# CITY OF ALBUQUERQUE

**Re: Dunkin Donuts**  
**2301 Juan Tabo Blvd NE**  
Architect's Stamp dated 01-08-16 (H21D051)  
Certification dated 08-16-16

## DRAINAGE AND TRANSPORTATION INFORMATION SHEET (REV 09/2015)

Project Title: Dunkin Donuts Building Permit #: \_\_\_\_\_ City Drainage #: H21D051  
 DRB#: \_\_\_\_\_ EPC#: \_\_\_\_\_ Work Order#: \_\_\_\_\_  
 Legal Description: Snow Heights Addition, Parcel 1-A, Block 88-B  
 City Address: 2301 Juan Tabo Blvd NE

NEW DUNKIN DONUTS
2301 JUAN TABO BLVD NE
C1.1 - Grading Plan
PC NUMBER

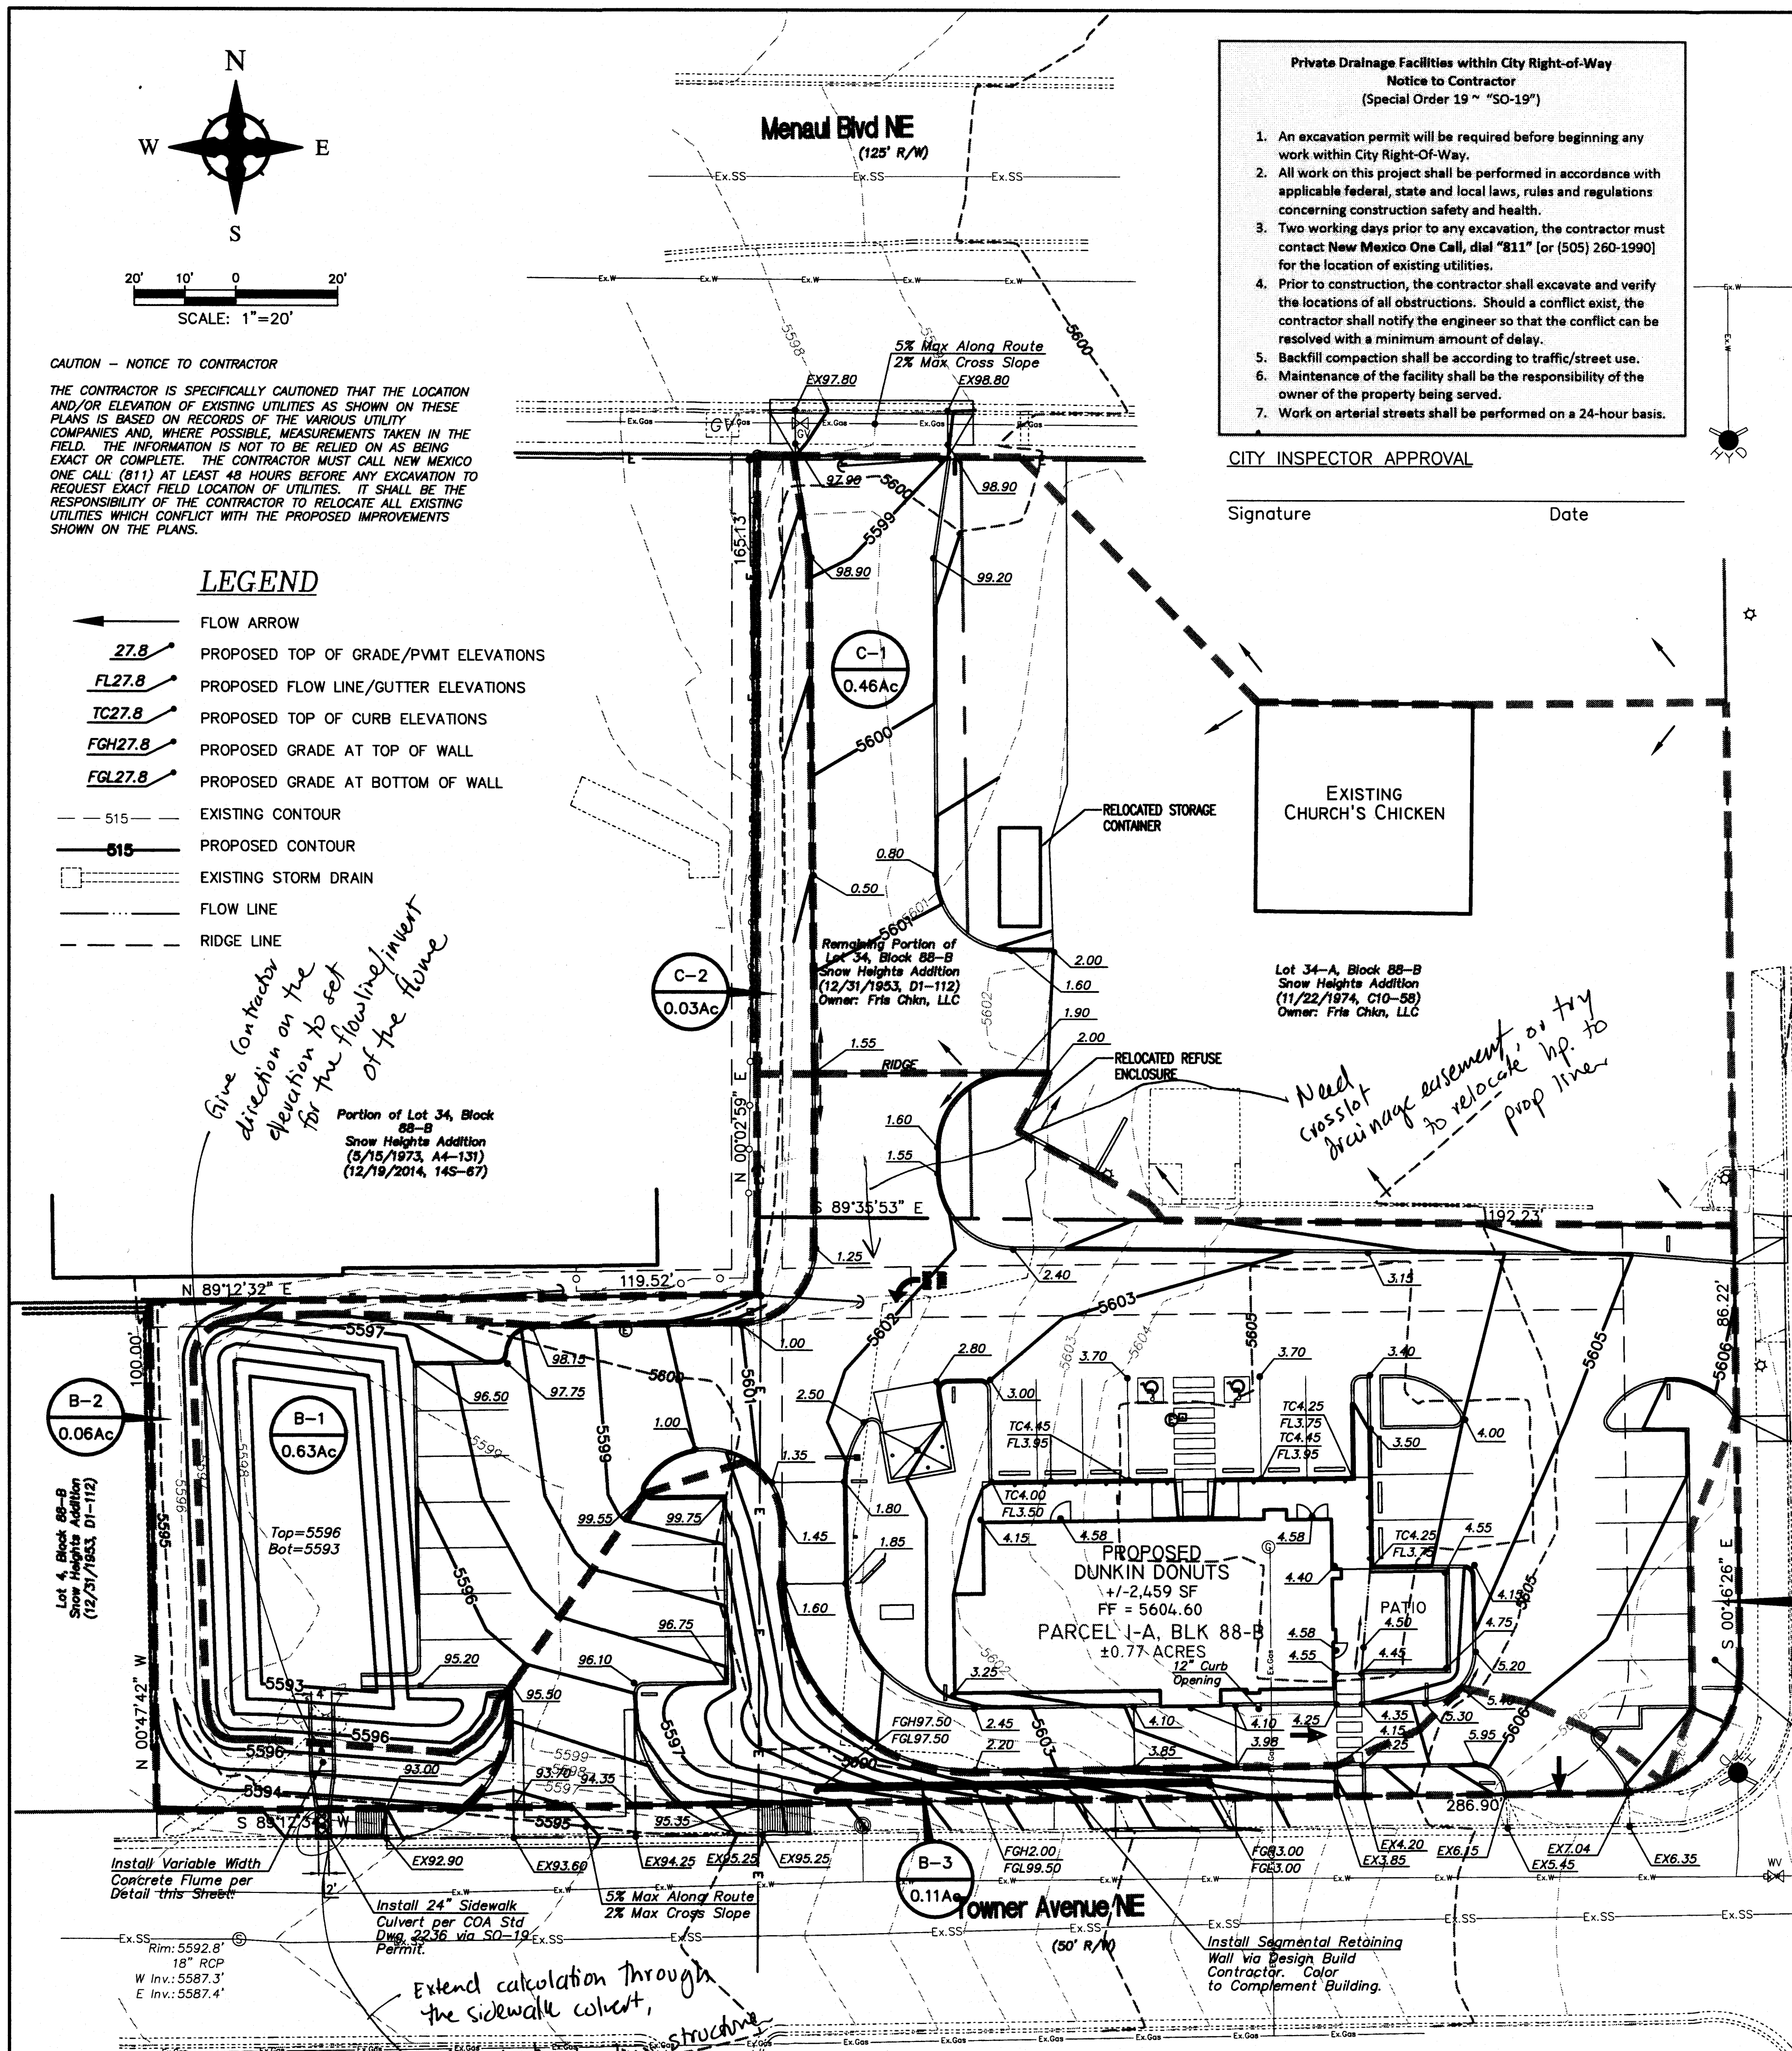
- The outlet of the pond narrows from 4' at the flume, to 2' at the sidewalk culvert. The capacity calculation of the outlet is based on the 4' flume, but the 2' culvert appears to be the limiting structure, so its capacity should also be included.
- The flume outlet should include a flowline (or top of curb) elevation at the crest to ensure that the intended pond volume is maintained.
- Some flows from the N-S access aisle are directed south across the lot line between Parcel I-A and Lot 34. A cross-lot drainage easement may be needed. Alternatively, the high point (ridge) could be aligned at the lot line.

SITE DETAILS

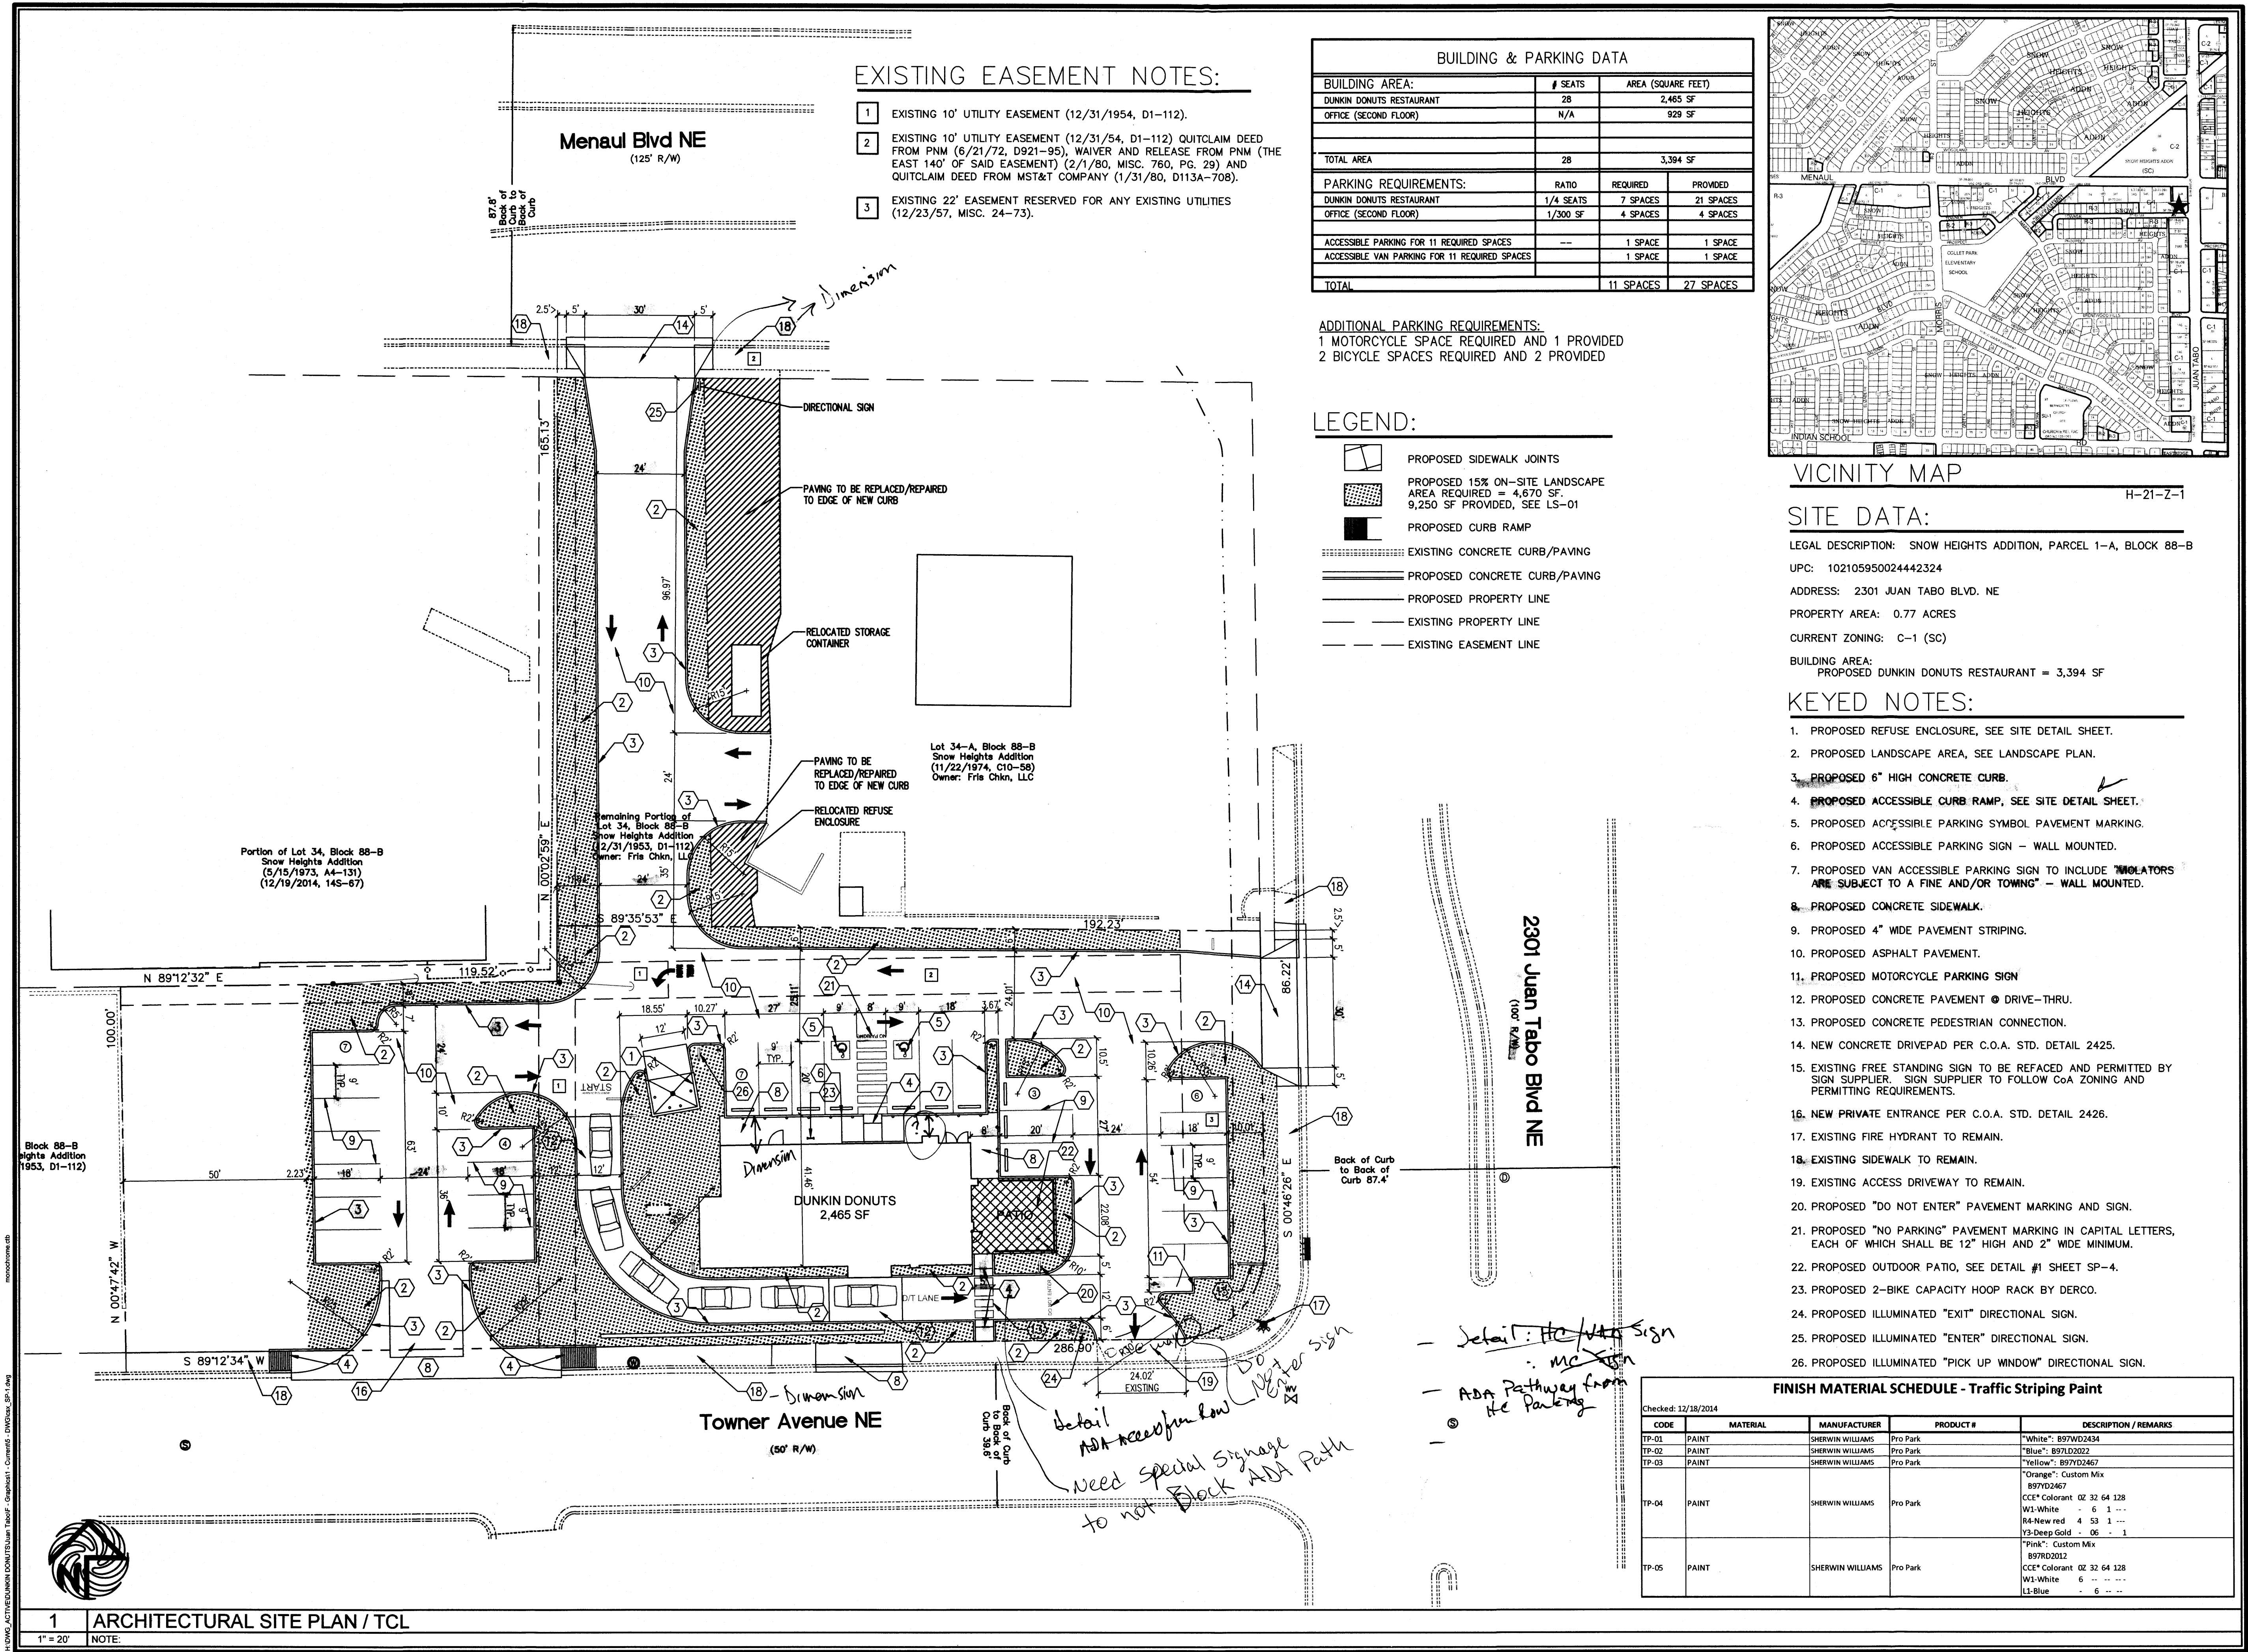
1. Please dimension and detail all existing sidewalks, right of ways and ADA access ramps per COA standard drawing. Please attach Site Detail Sheet.
2. Per the DPM, a 6 ft. wide ADA accessible pedestrian pathway is required from the public sidewalk to the building entrances. Please add sign at the south side of building at the end of the Drive Thru and before the ADA pedestrian crossing to building entrance informing vehicles to not stop or block this area.

3. Per the DPM, a 6 ft. wide ADA accessible pedestrian pathway is required from the HC parking stall access aisles to the building entrances. Please clearly show the sidewalk dimension.
